Case Officer: Rebekah Morgan

Applicant: Mr Kirkman

Proposal: New detached two storey house with detached garage - Re-submission of 23/01365/F

Drawing Title:
PROPOSED FRONT & REAR ELEVATIONS

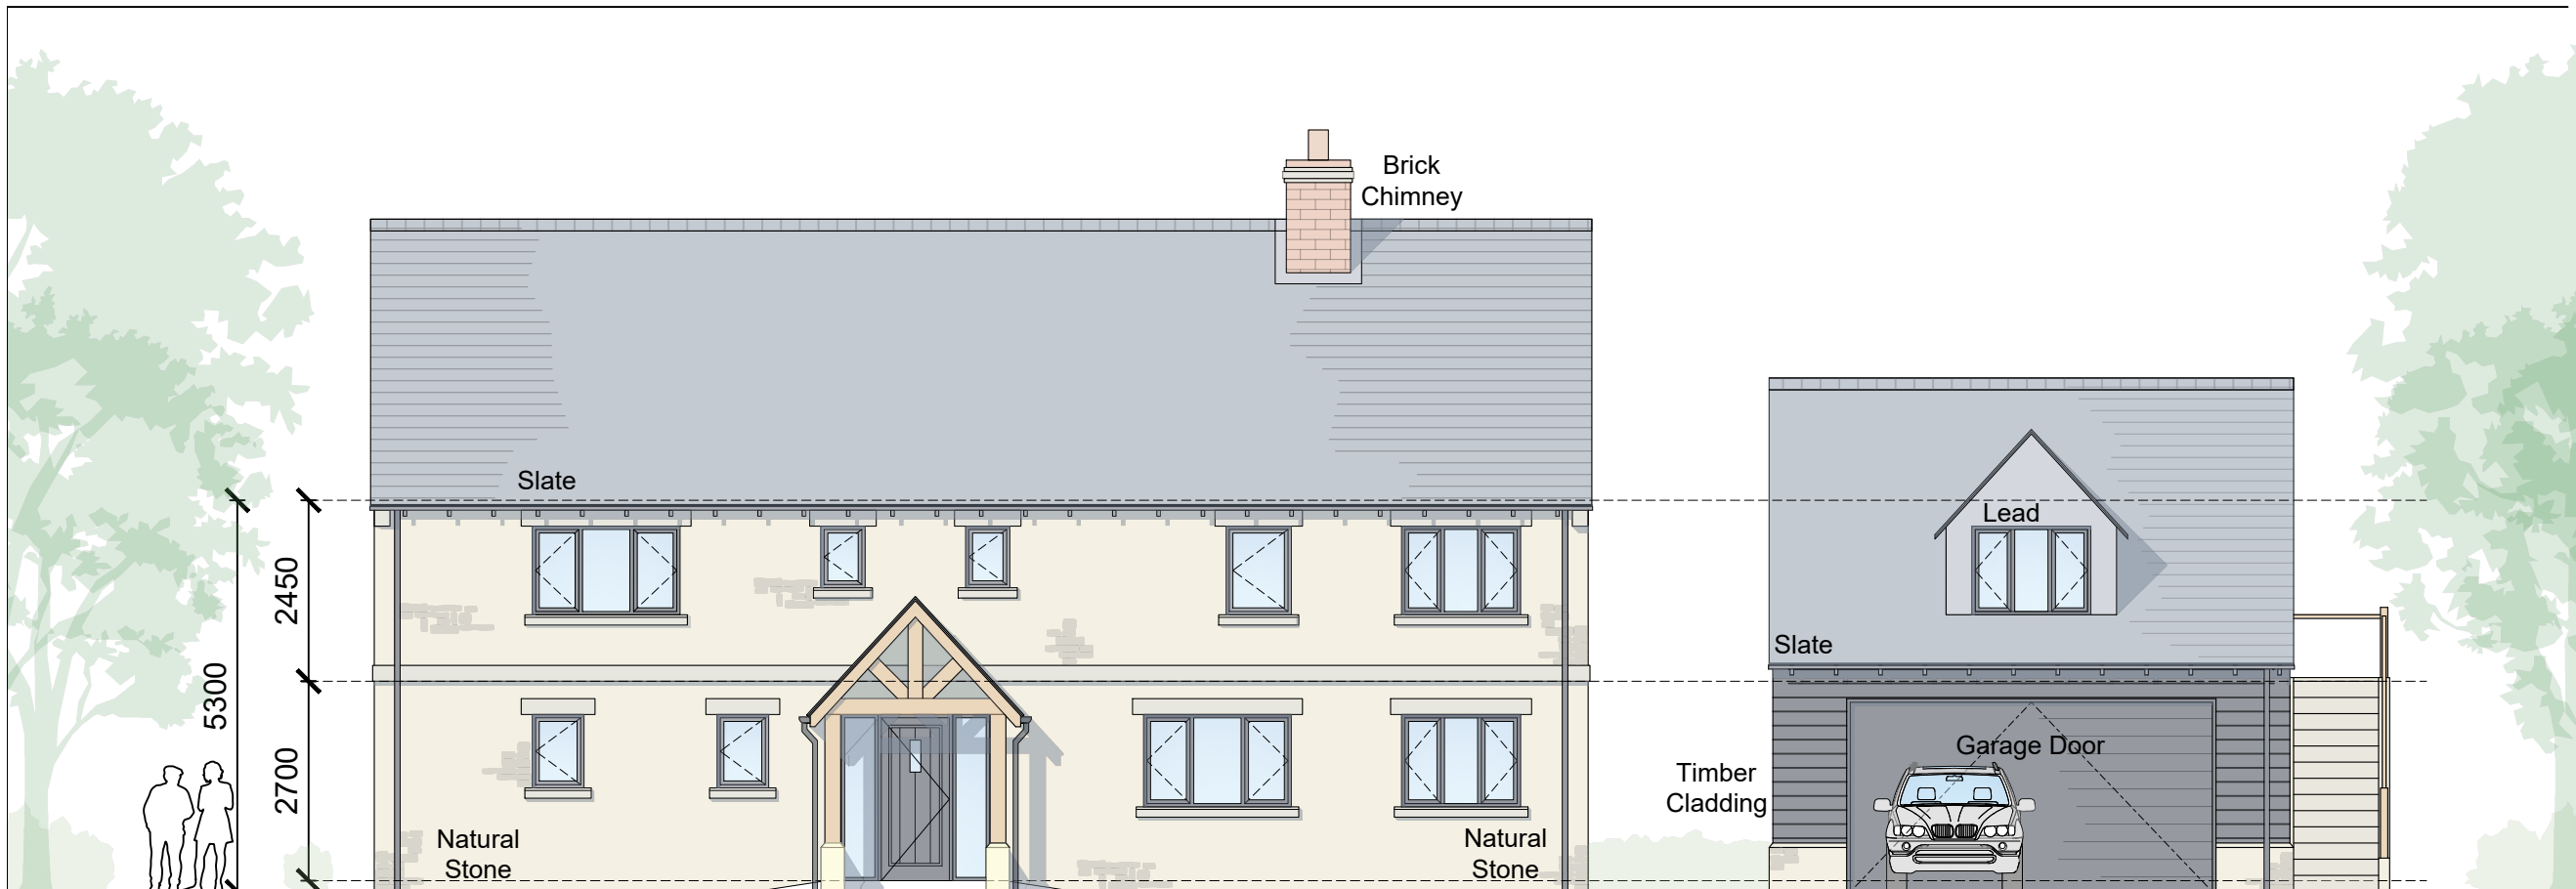
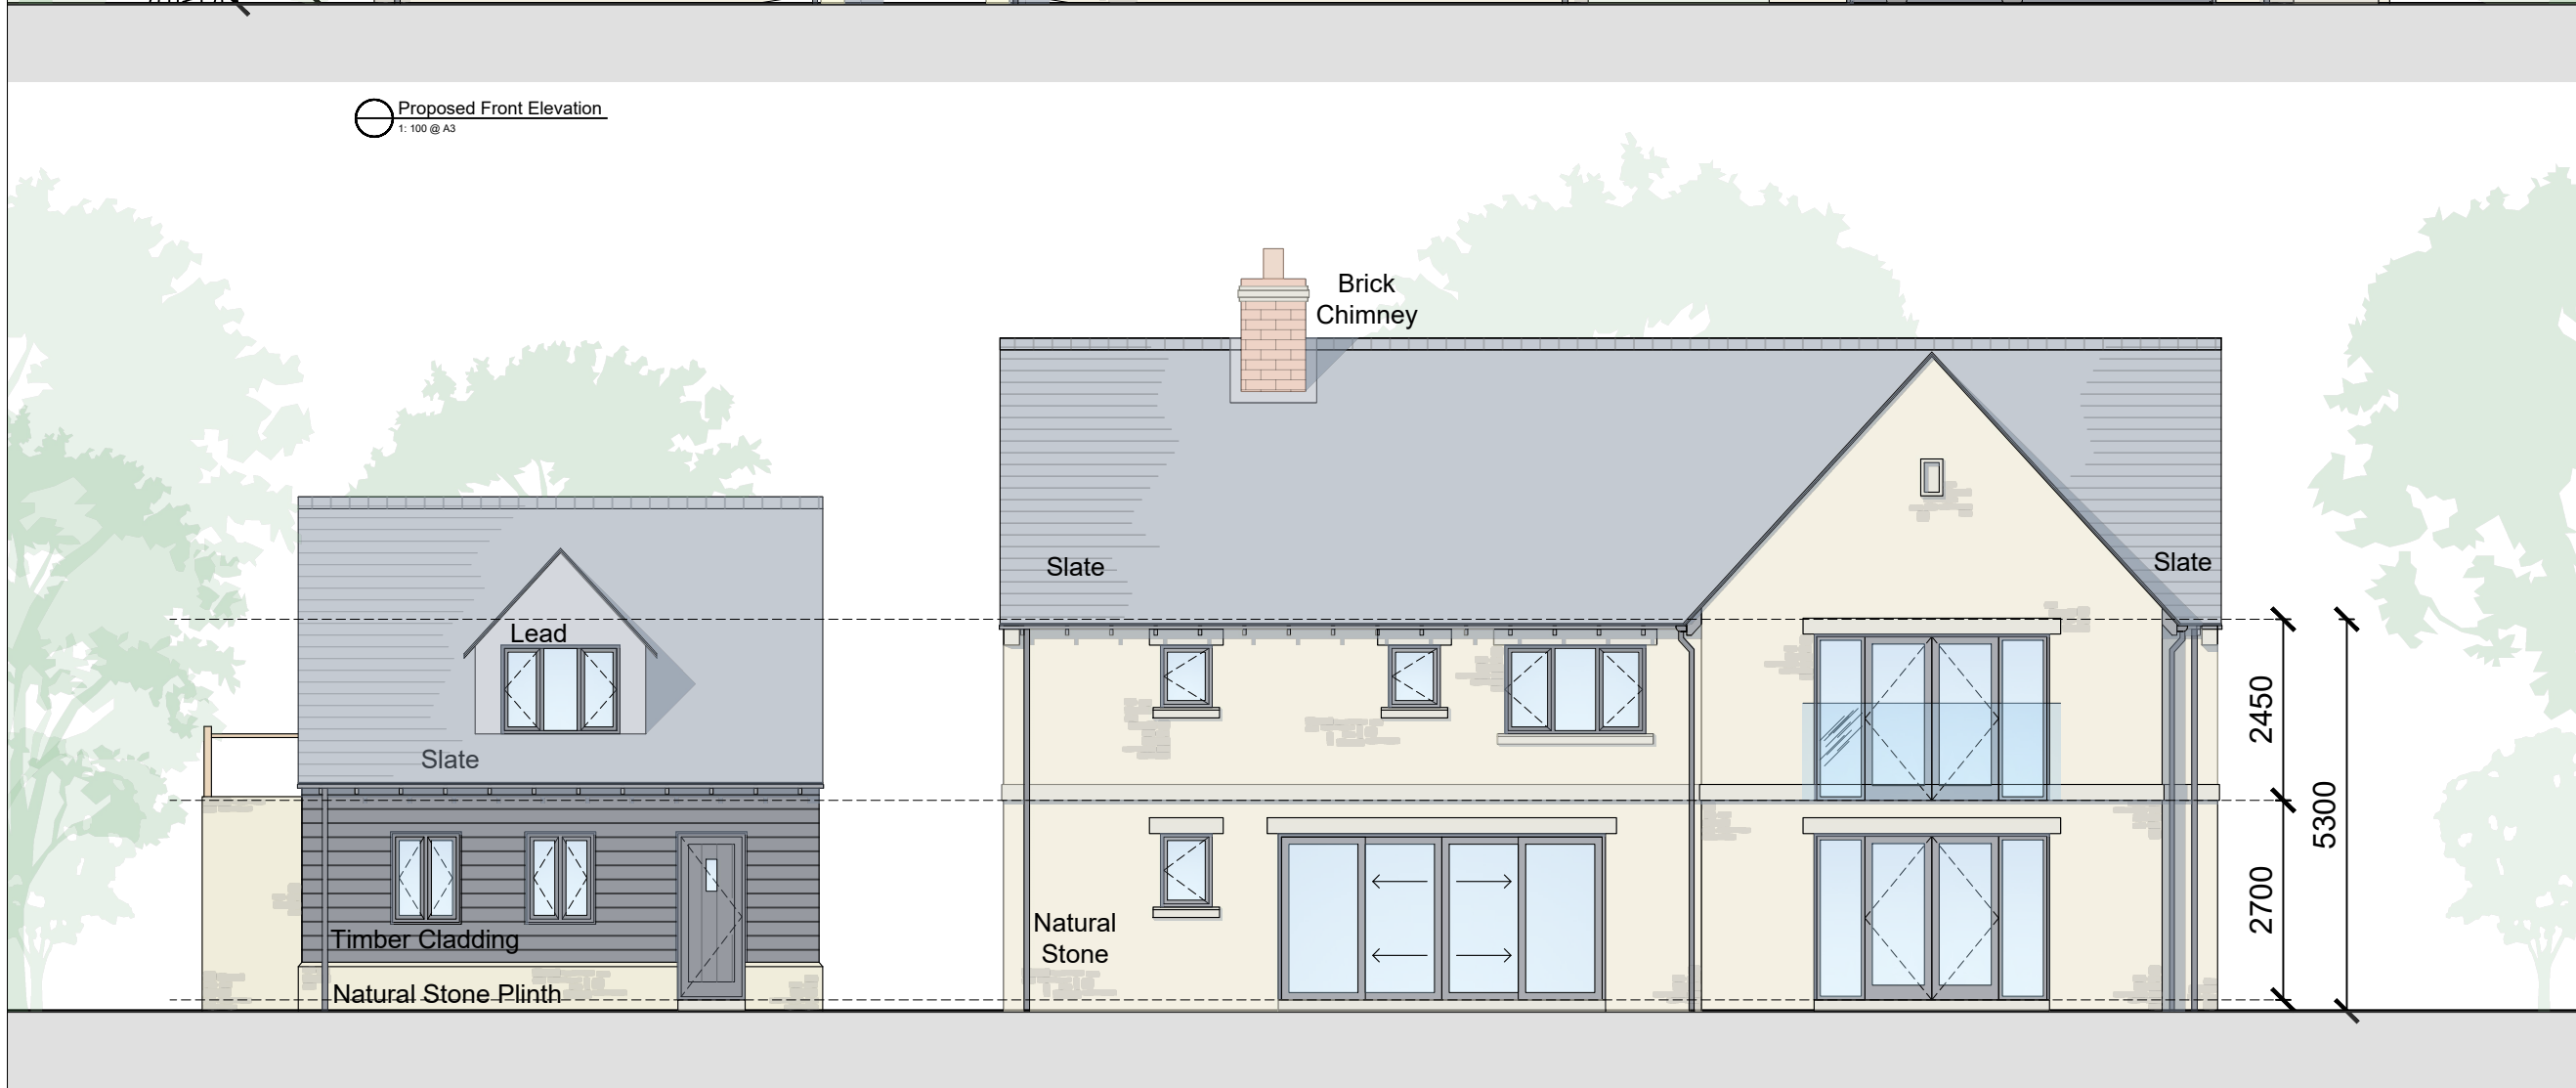
The design and massing of the proposed dwelling is considered to be out of keeping with the properties within the village and also to dominate and detract from the Listed Building, therefore rendering it to be considered to be inappropriate in this location. This is a sensitive site, and it is considered that any development here would be difficult to achieve, but something more akin to a modest cottage within the grounds or converted outbuildings may be more acceptable and have less of an impact.

- 8.27. The design of the proposed dwelling is considered to be out of keeping with the properties within the village. The proposed dwelling is large, with a wide span across the frontage and deep projection to the rear. Although the building is proposed to be constructed in stone, the proposed fenestration and layout are not traditional in design. The addition of a detached garage increases the overall size of the development on the site, particularly due to its height and the inclusion of dormer windows which give this 'outbuilding' a prominent appearance.
